Department of Primary Industries

17 November 2015

Kings Forest Project Approval MP08_0194 MOD 3

Fence Detail

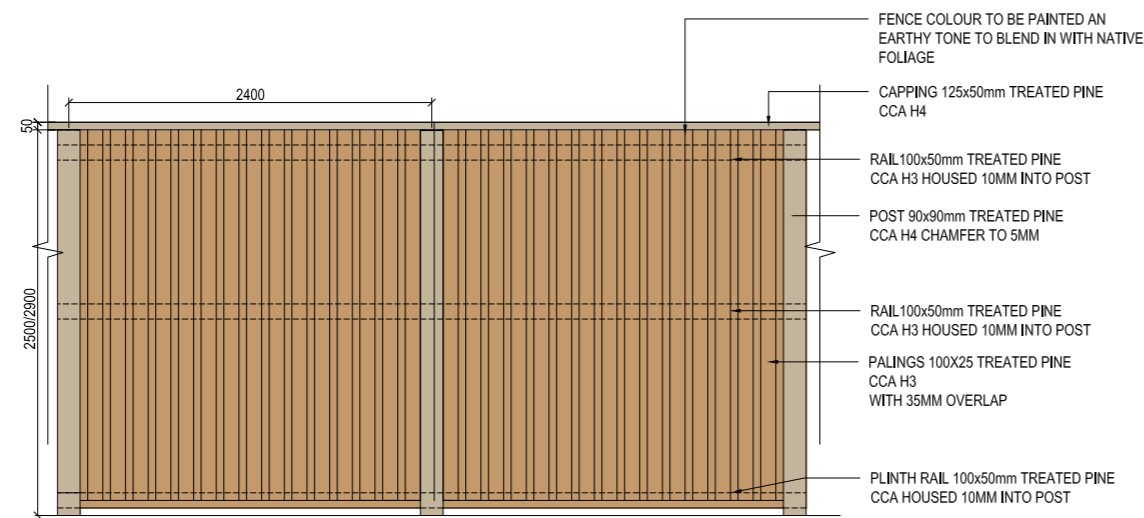
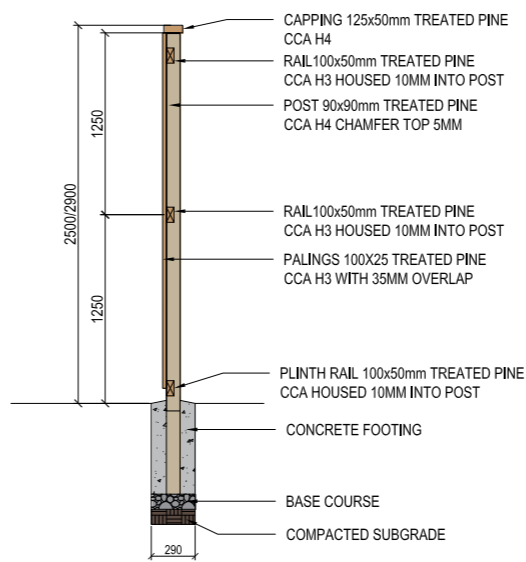
The proponent proposes a 2.5m colourbond fence plus an additional planting of 15m high trees and a dense hedge on the southern side of the fence to address potential land use conflict risk.

The proponent also indicates that a 10m wide wallum scrub vegetative buffer on the neighbouring landowner's property will provide further protection. A vegetative buffer on a neighbouring property should not be seen as the proponent's commitment to mitigating land use conflict risk as there is no onus on the neighbouring landowner to keep/maintain the vegetative buffer. It is therefore necessary to consider whether the proposed fencing and landscaping on the subject site is adequate to address potential conflict risk between the service station and current/future agricultural use of the neighbouring land. DPI has no further comments in this regard. If the buffer provisions provided on the subject site are considered adequate, then there should be a condition that requires continued maintenance of the buffer within the conditions of consent.
